WEST SUSSEX COUNTY COUNCIL CONSULTATION

TO:	Arun District Council FAO: Simon Davis
FROM:	WSCC - Highways Authority
DATE:	1 August 2019
LOCATION:	Yapton Metal Company, Burndell Road, Yapton, BN18 0HP
SUBJECT:	Y/42/19/DOC Approval of details reserved by condition imposed under ref Y/53/16/PL relating to Condition Nos 3 - surface water drainage, 4 - maintenance & management of SuDs system, 5 - site set up and 7 - protective fencing/site monitoring. Attached plan received.
RECOMMENDATION:	No Objection

West Sussex County Council, in its capacity as the Local Highway Authority (LHA), have been re-consulted on discharge of conditions attached to approval Y/53/16 (4 x dwellings and access works).

Site Plan (Proposed) 1:200

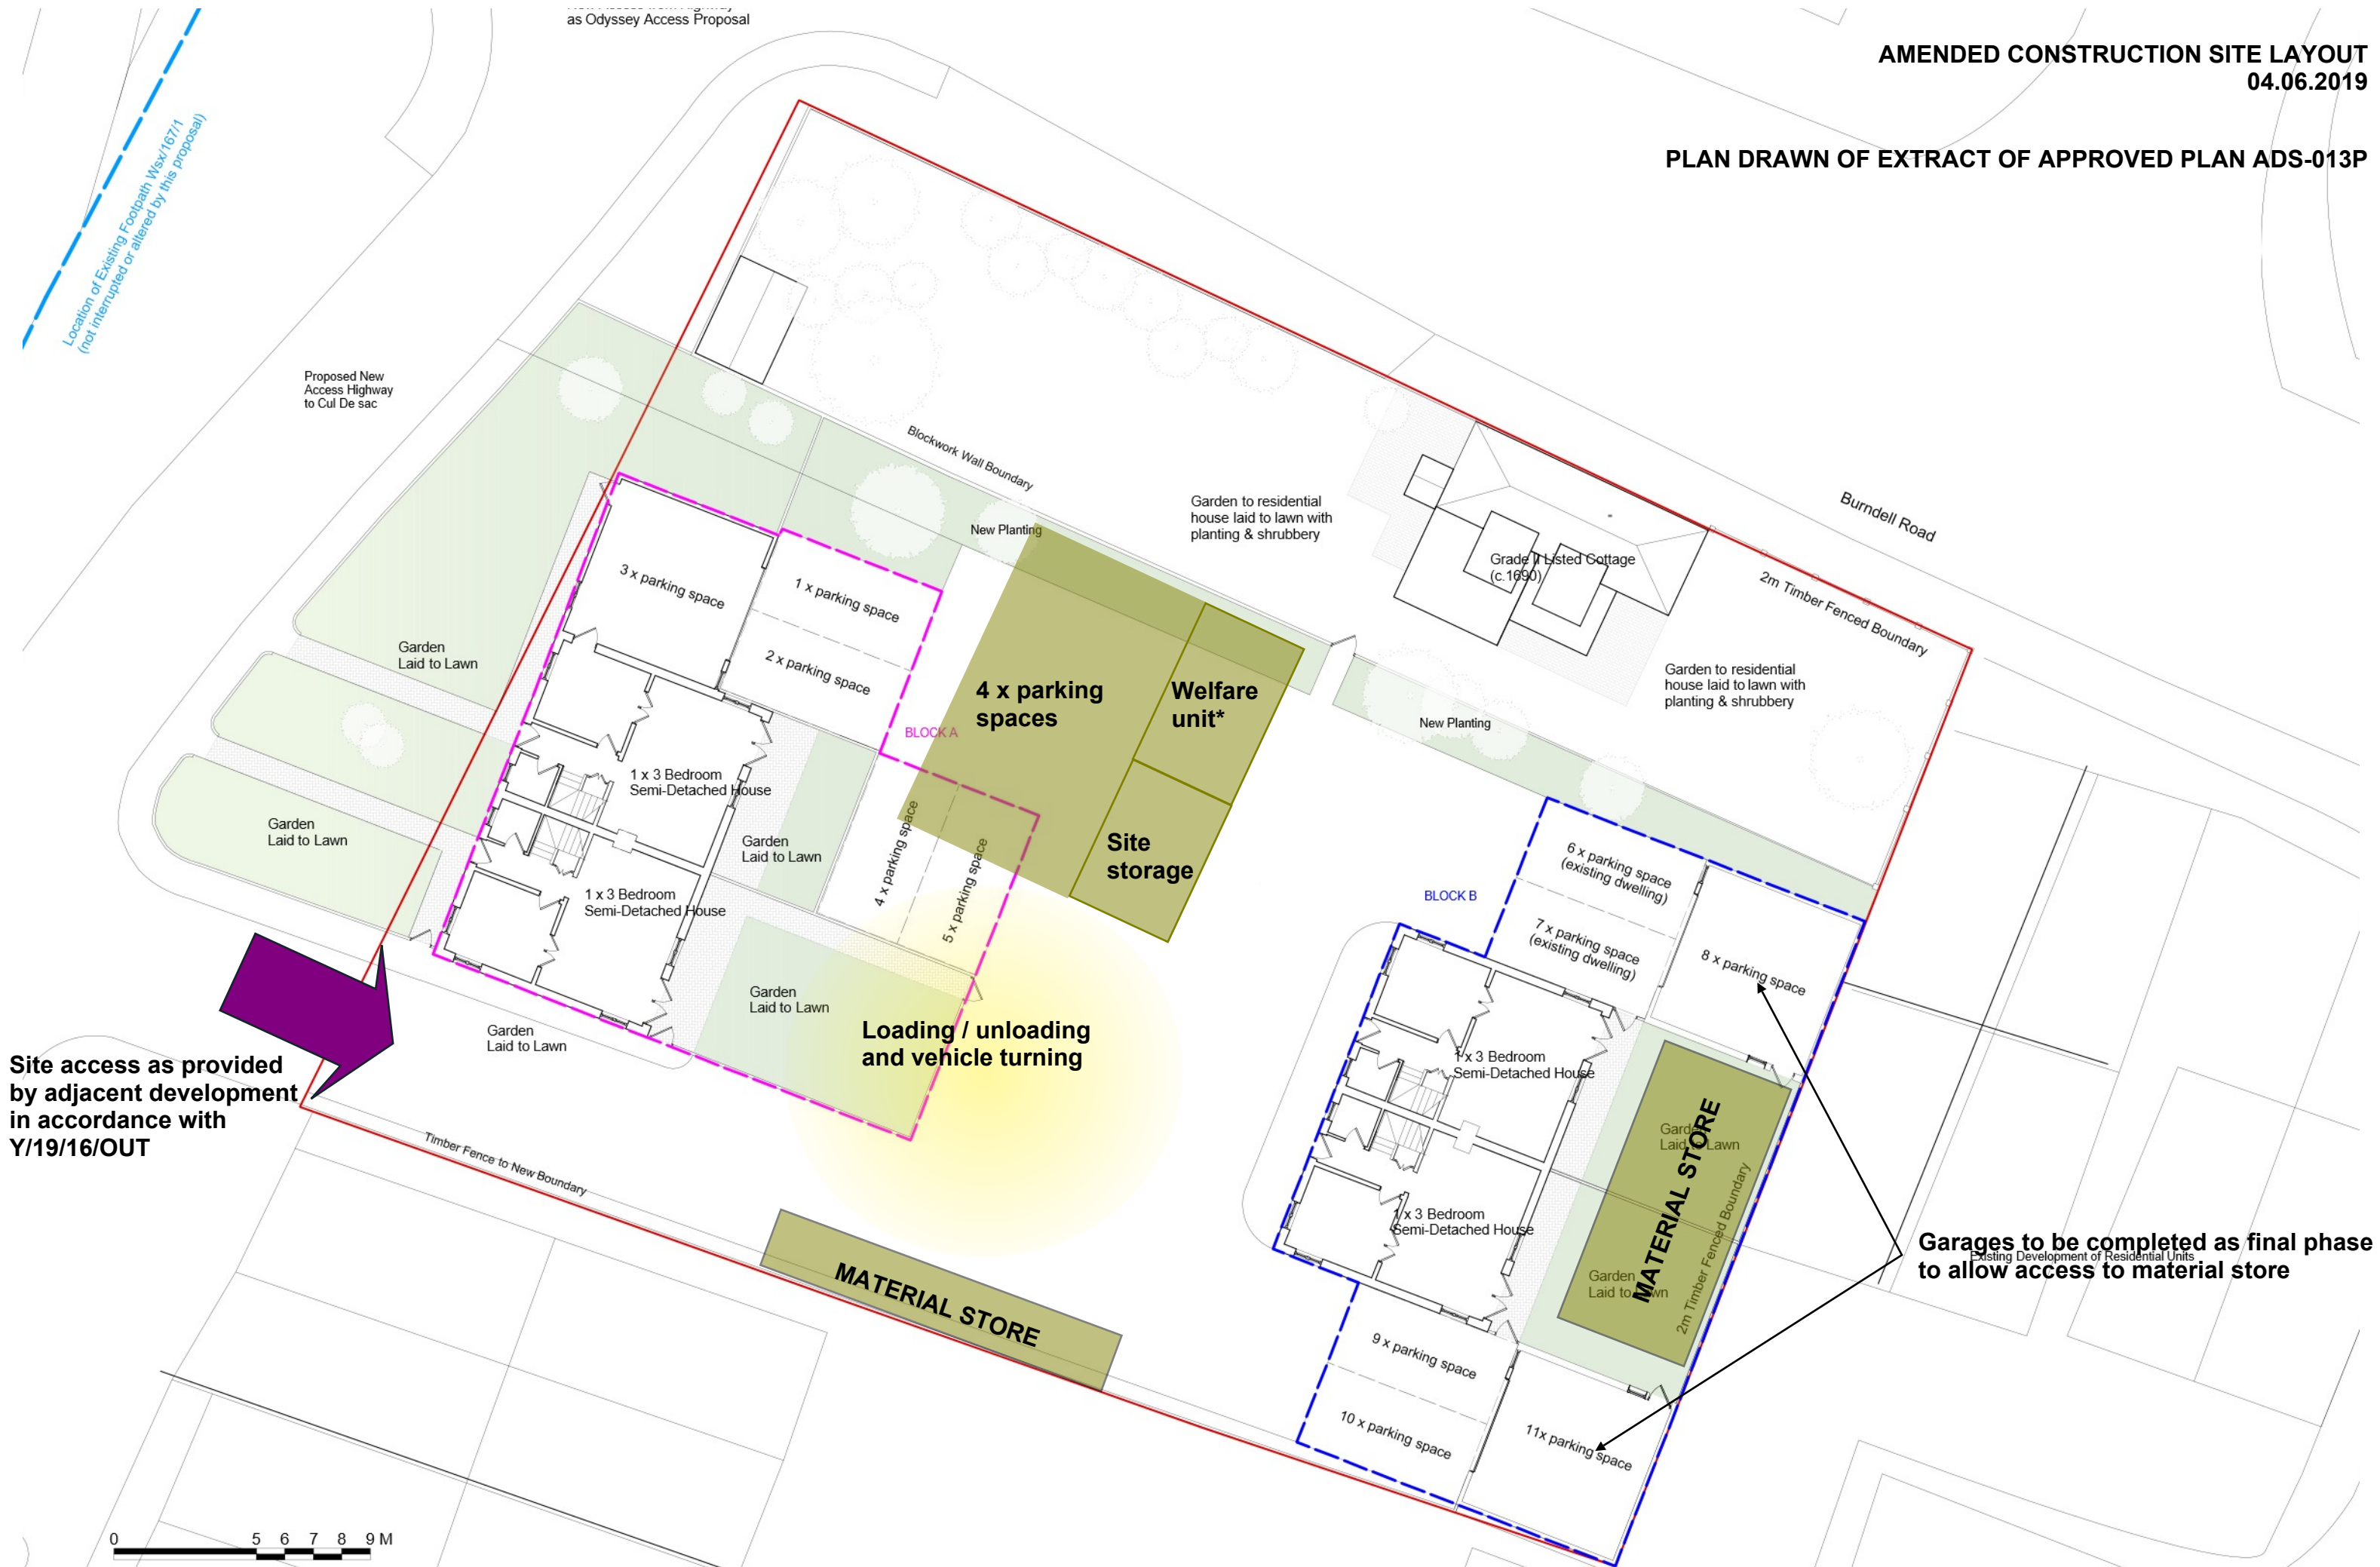
In LHA comments dated 28 May 2019 further information was requested with respect to condition 5 (site set-up during construction phase). The applicant was asked to clarify the proposed access arrangements for construction vehicles, including demonstration that vehicles can turn on site with the site-set up in place.

An amended construction site layout plan has been provided which indicates access will be via adjacent development. Loading/unloading area and ability for construction vehicle to turn within the site has also been demonstrated.

The LHA are satisfied with the submitted details and thus plans and details pertaining to condition 5 are acceptable.
